CITY OF ALBUQUERQUE

**Re: Car Crafters, 5404 Edith NE,
Request for Permanent C.O. –Accepted
Engineer's Stamp dated: 12-21-12, (F15/D036)
Certification dated: 08-11-12**

**Re: Car Crafters, 5404 Edith NE,
Request for Permanent C.O. – Not Accepted
Engineer's Stamp dated: 12-21-11, (F15/D036)
Certification dated: 08-11-12**

C102A

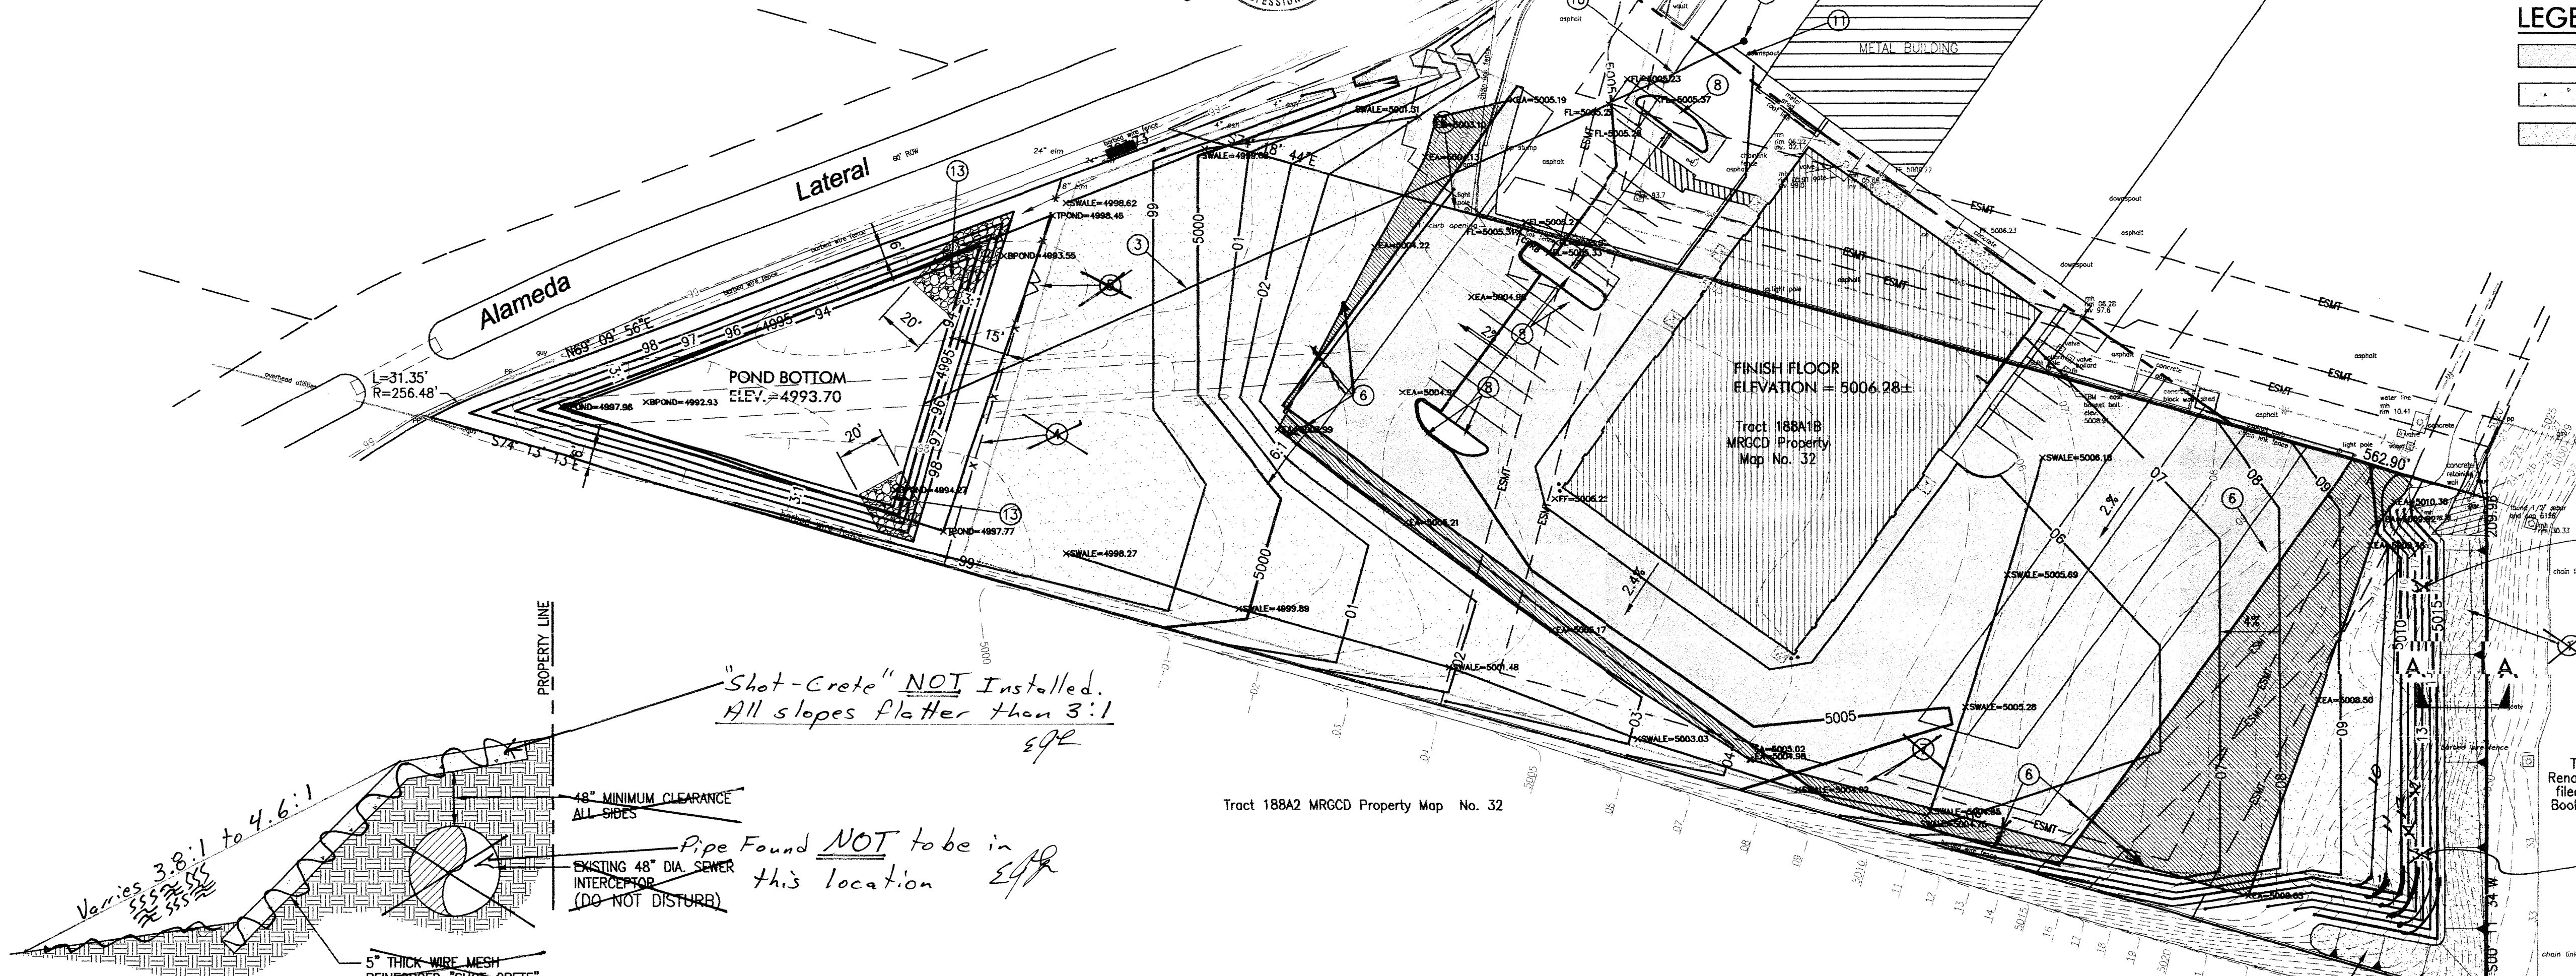
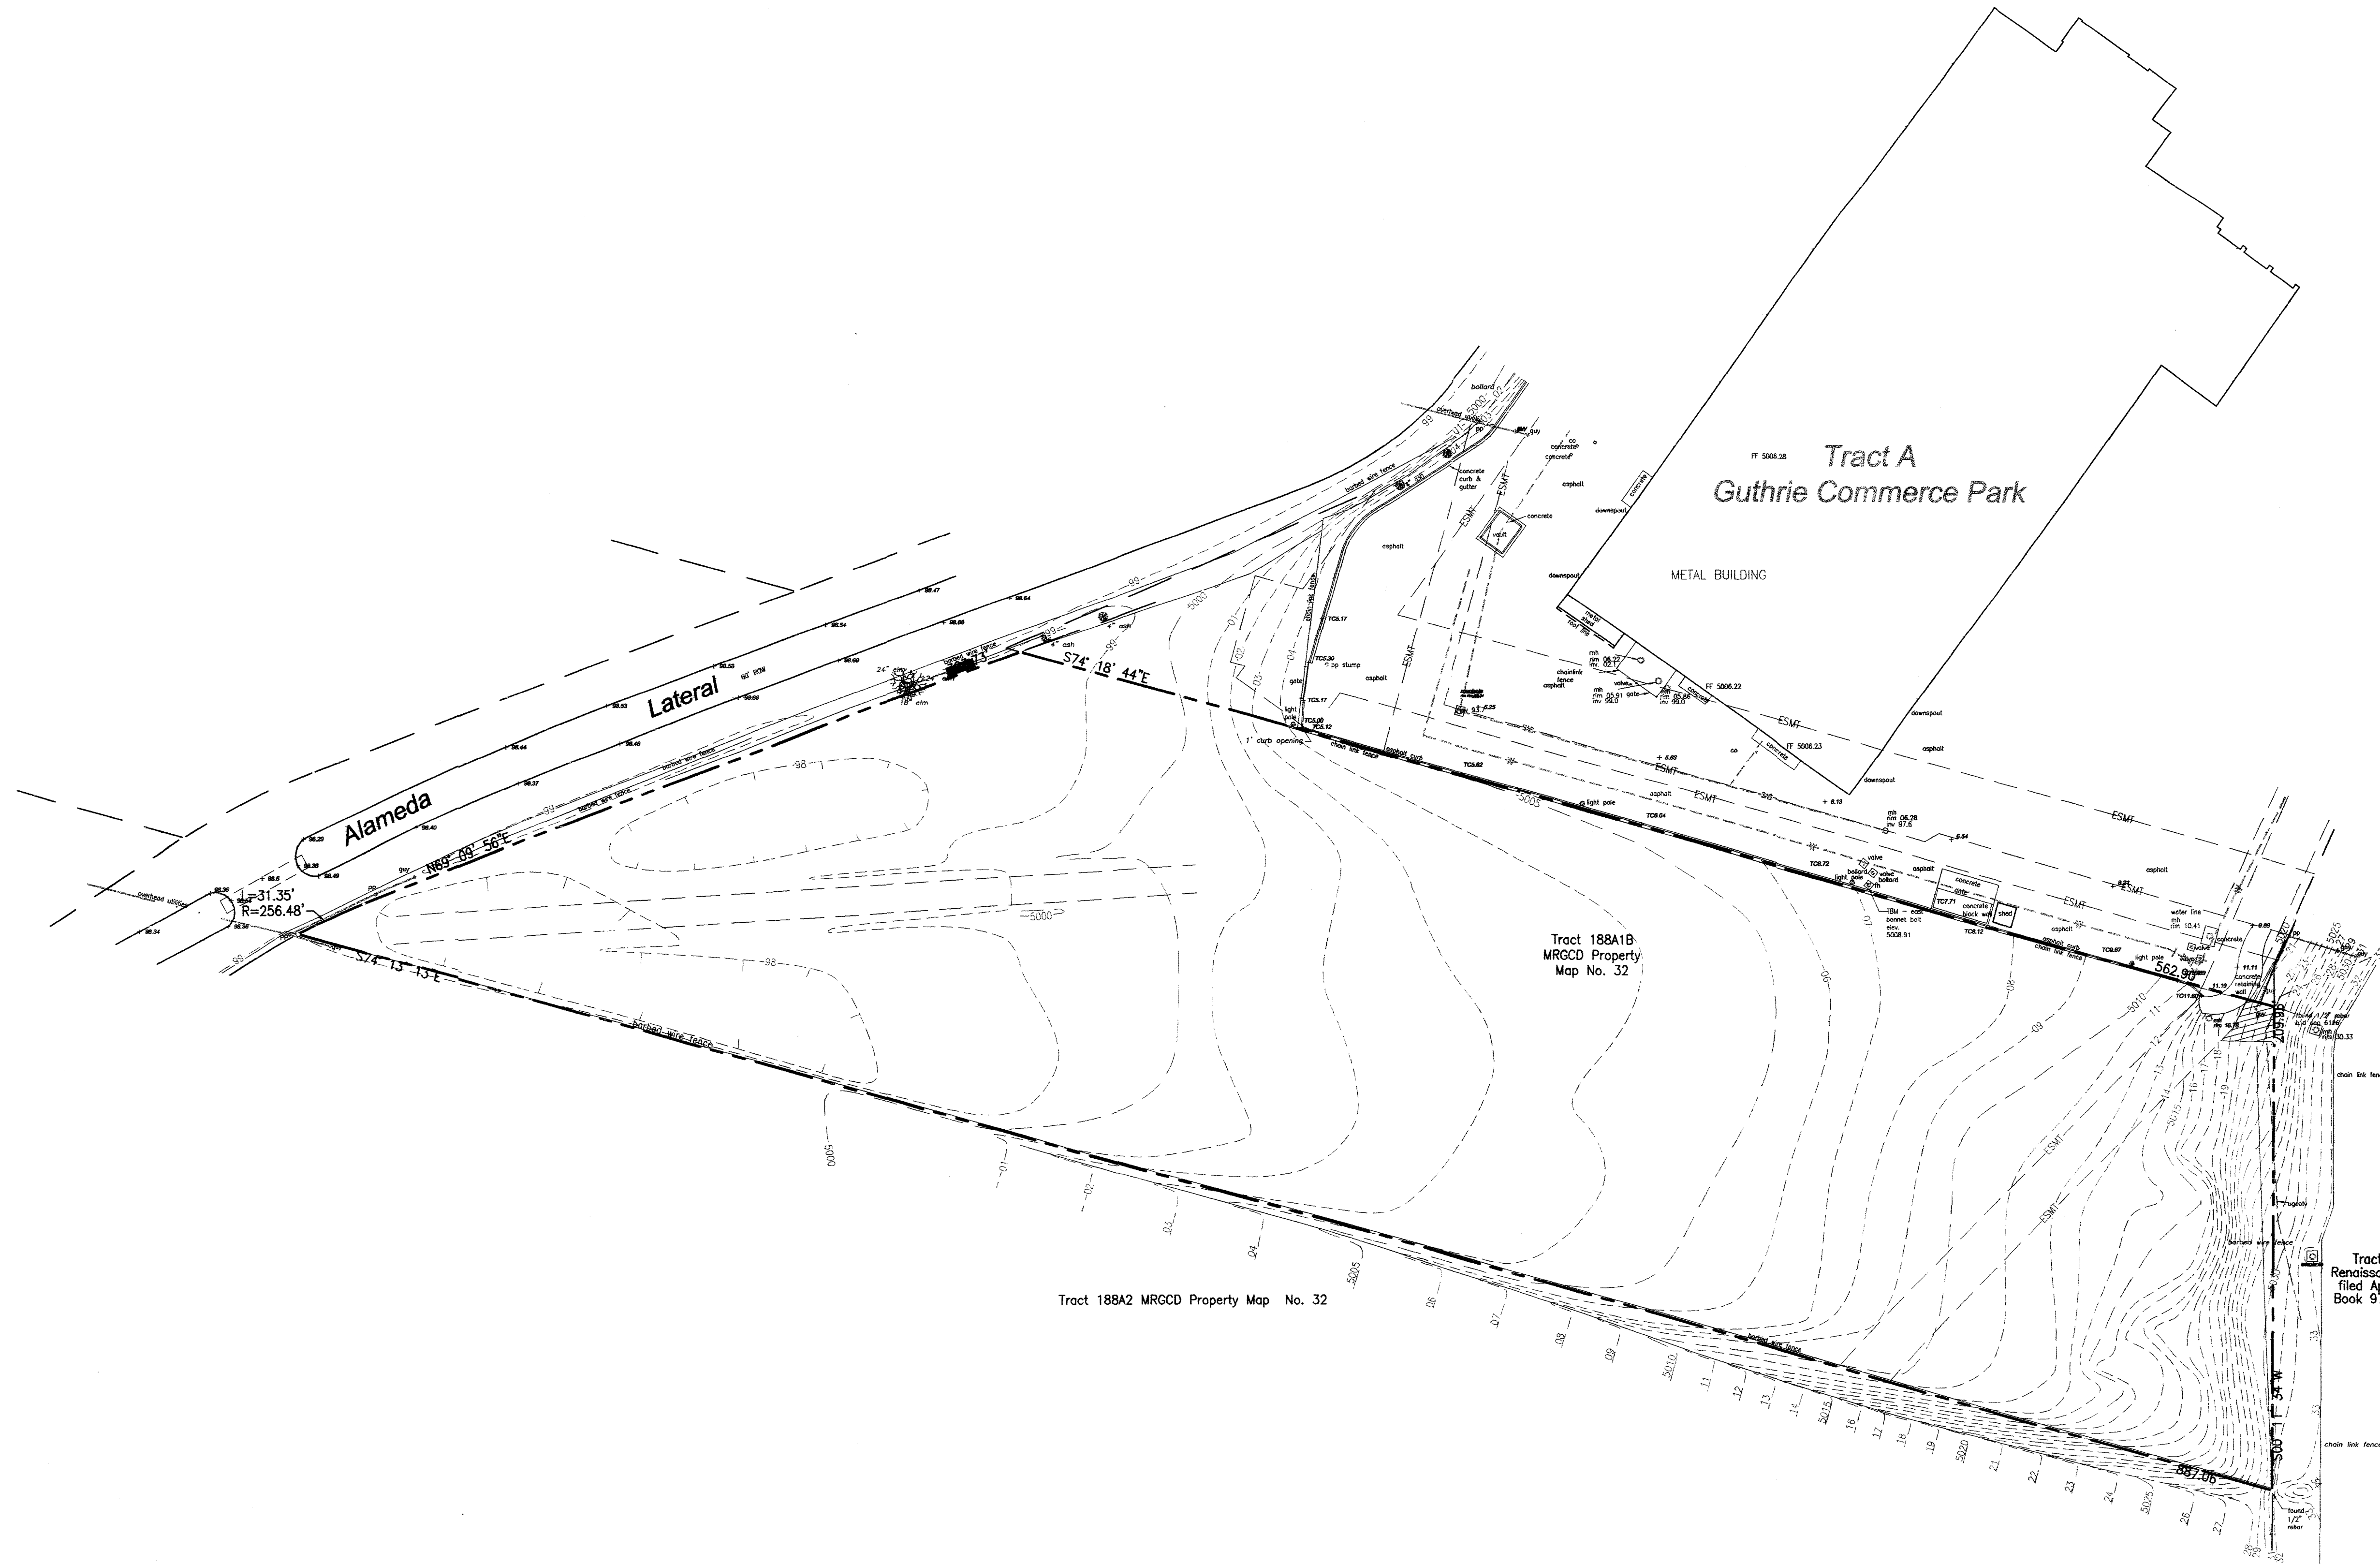
1. The eastern slope will require Shot-Crete per keyed note #1.
2. The plan should reflect current site conditions. Please indicate all details not constructed and show which keyed notes that are deleted or not used.
